# STERLING RANCH PHASE TWO PRELIMINARY PLAN

## STERLING RANCH PHASE 2 PRELIMINARY PLAN

El Paso County, Colorado

4  
4 OF 17

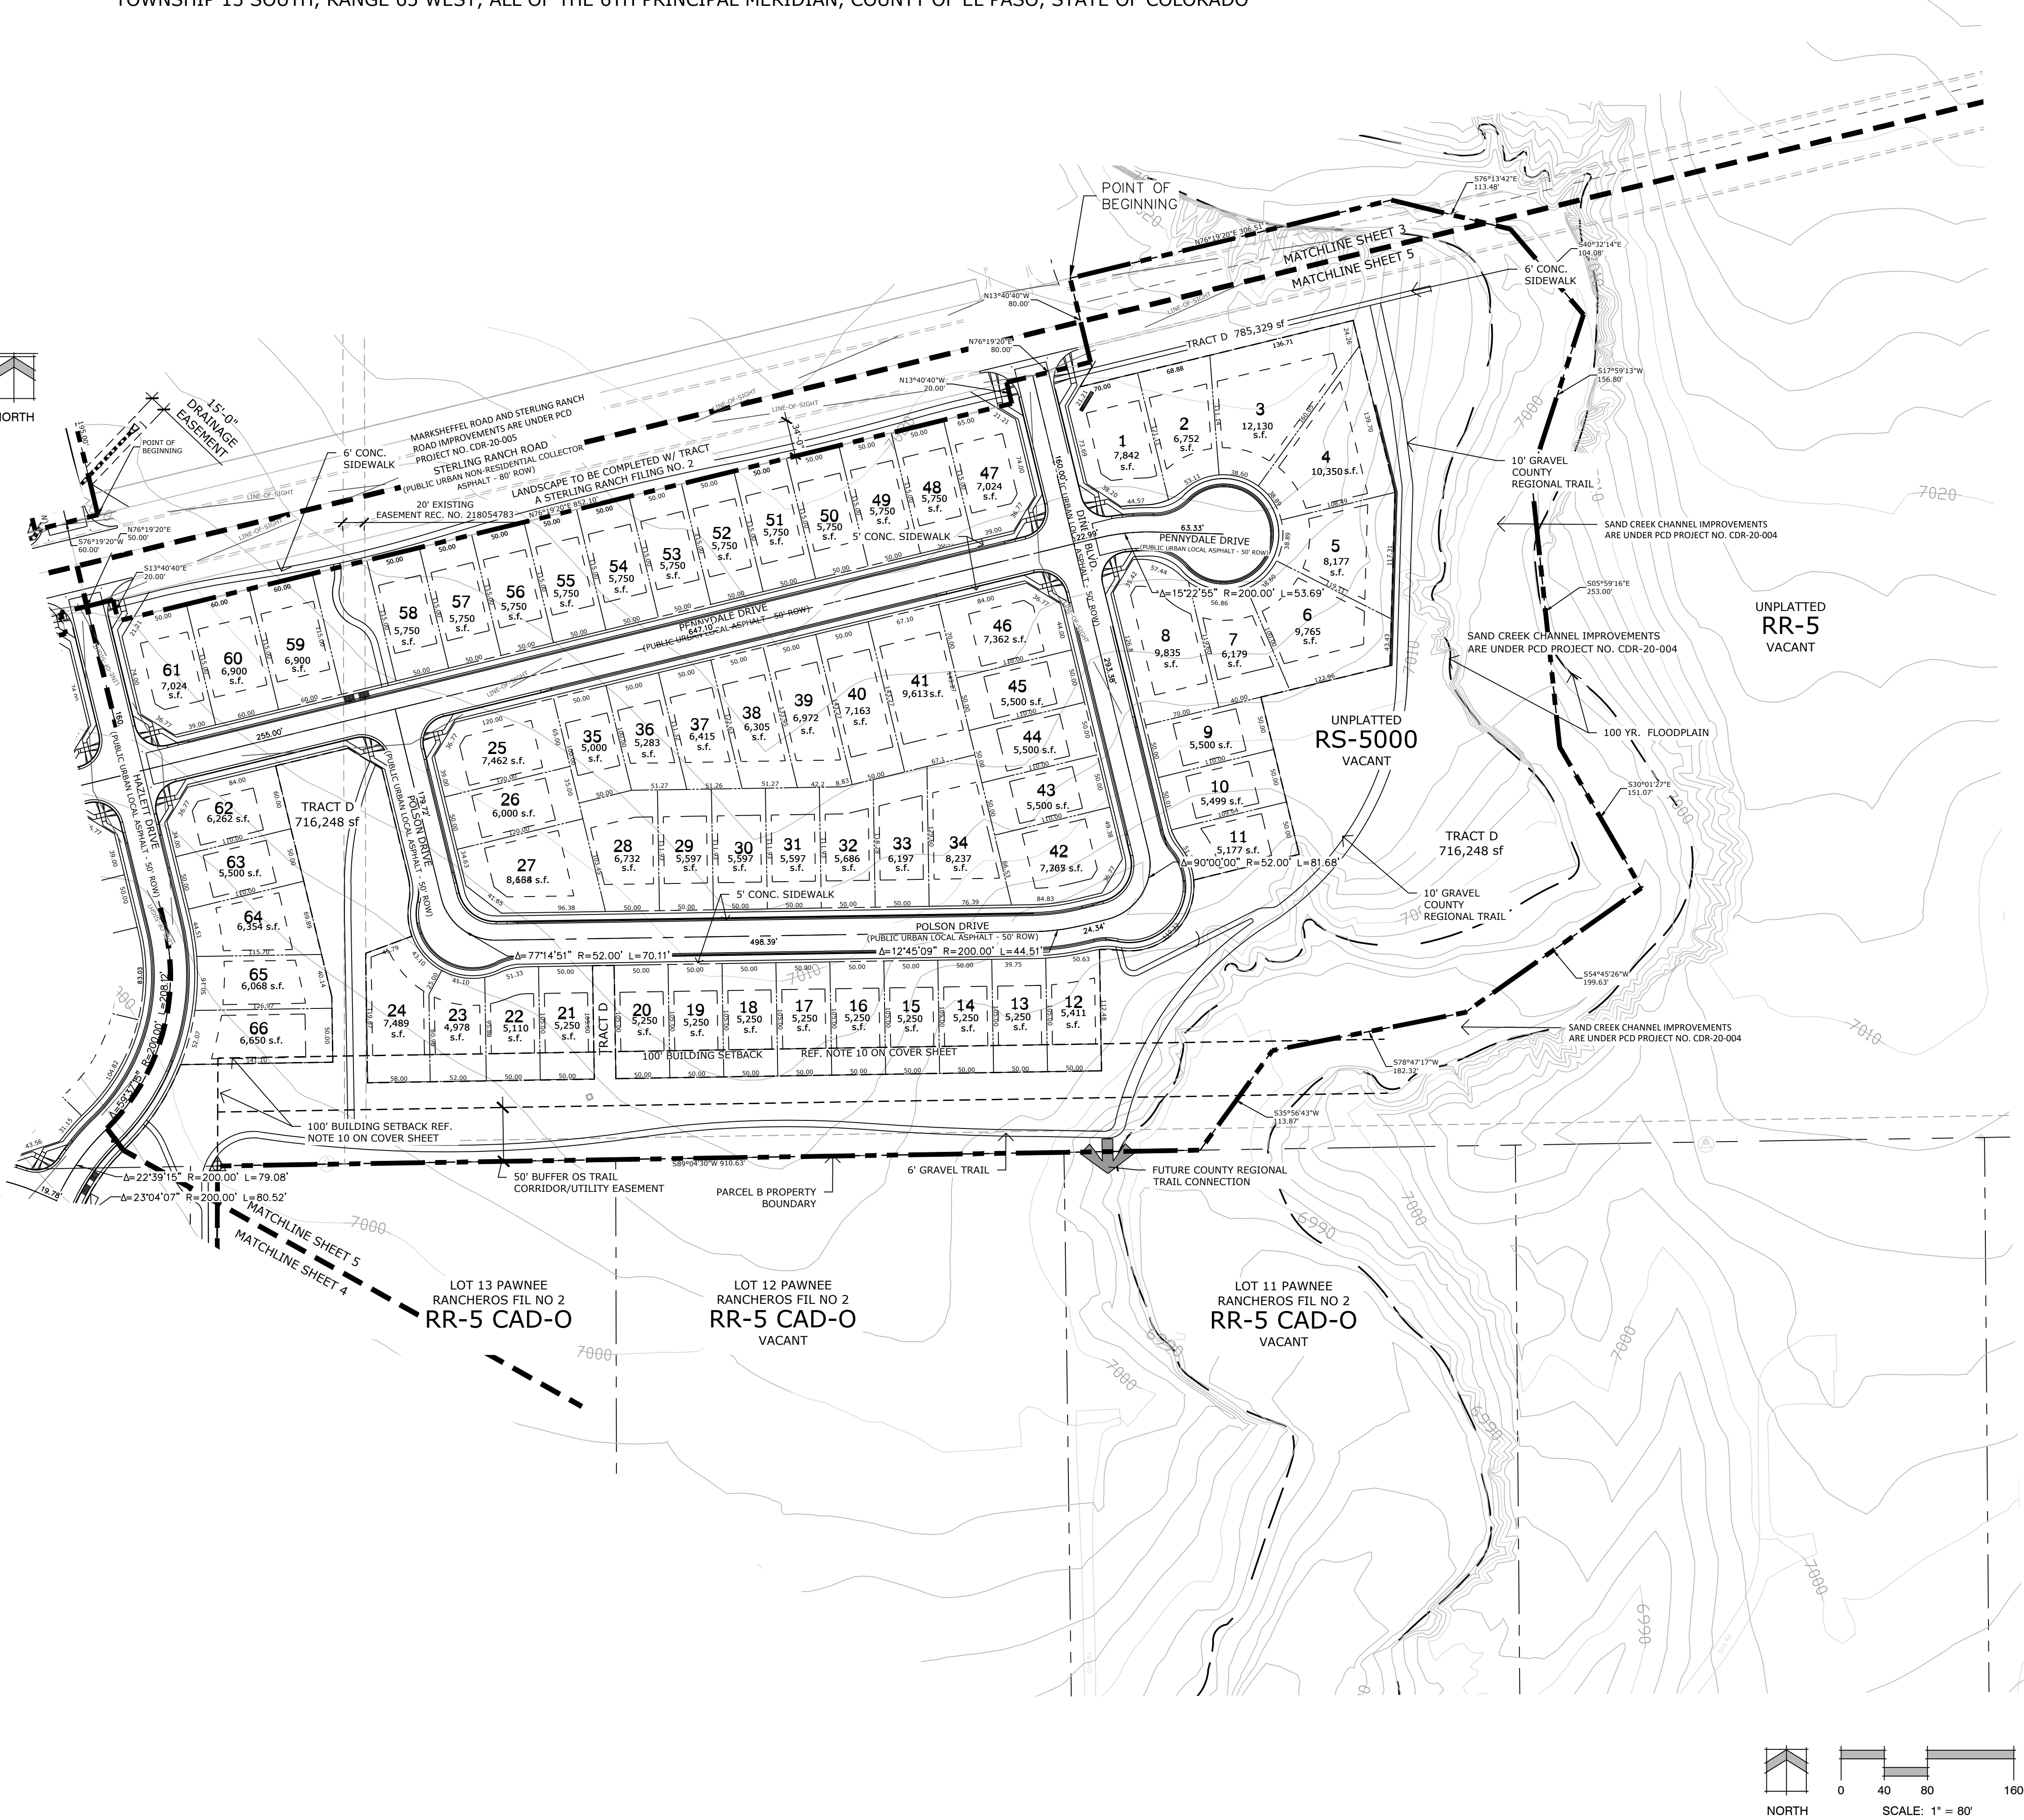
where does the tract stop and start? dimension, and boundary lines

REPEAT COMMENT: ALL TRACTS must be dimensioned w

5
OF 17

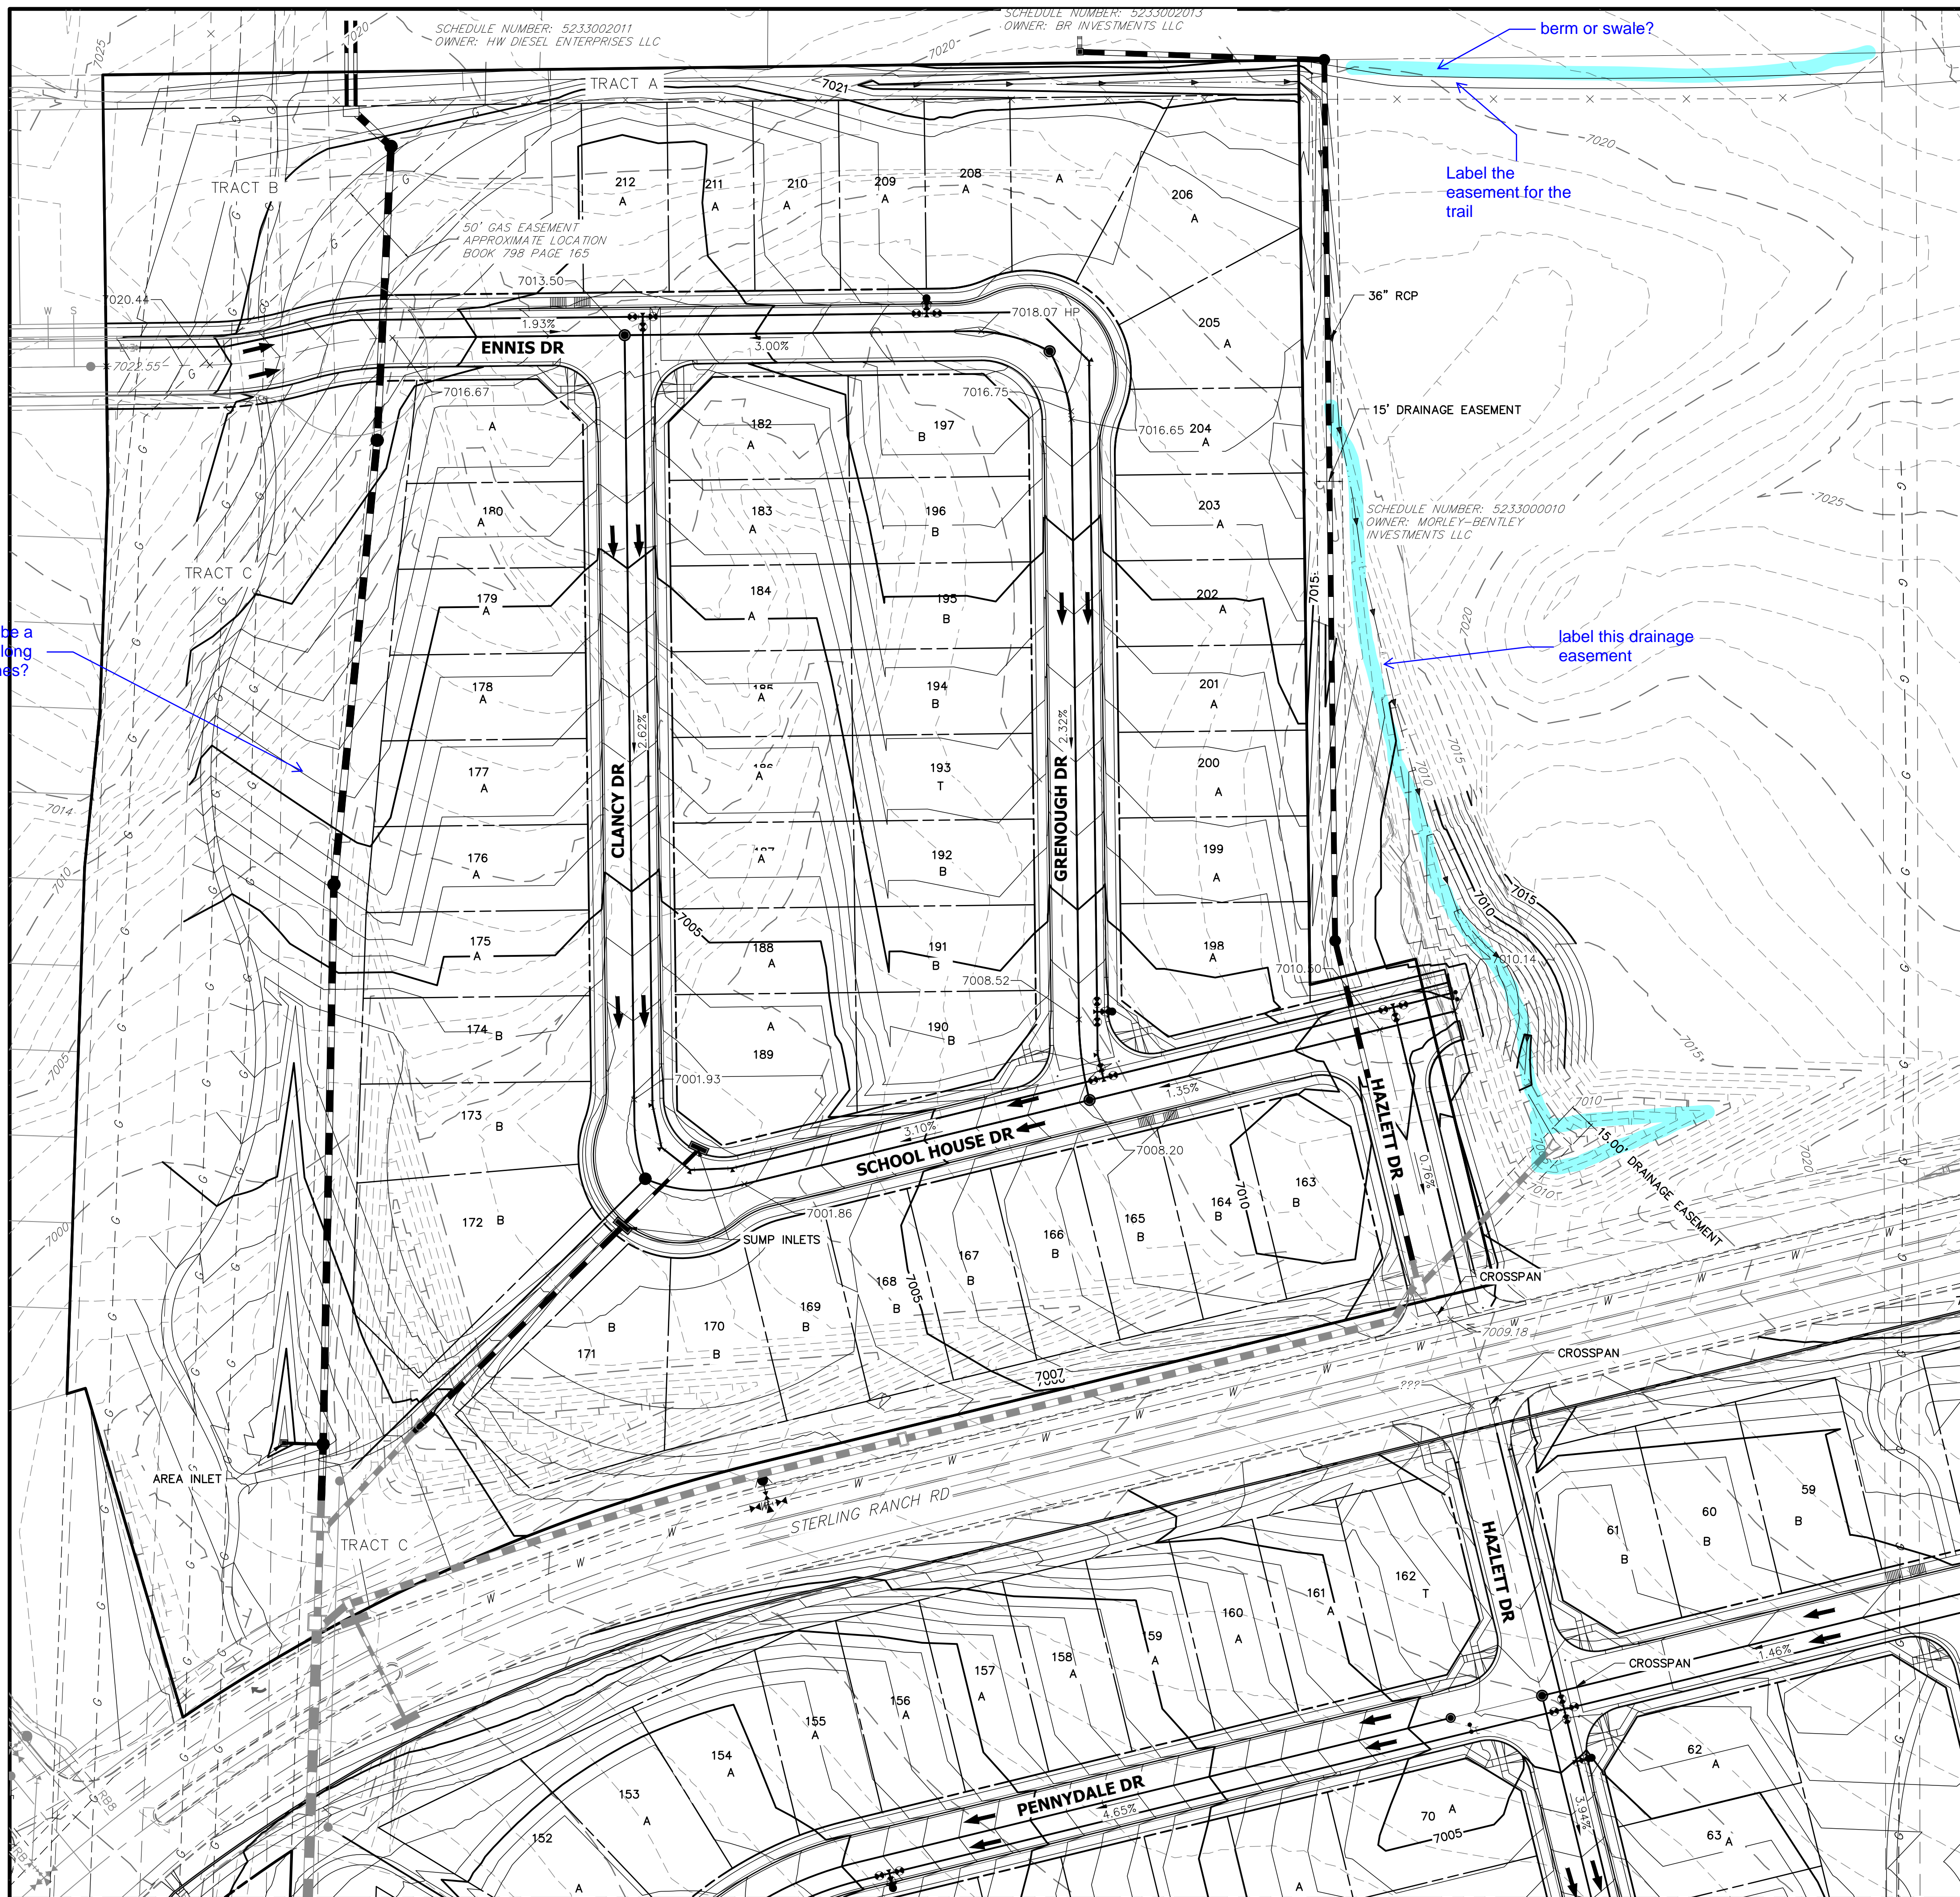
Dimensions/ Tract boundary shall close (Repeat comment)
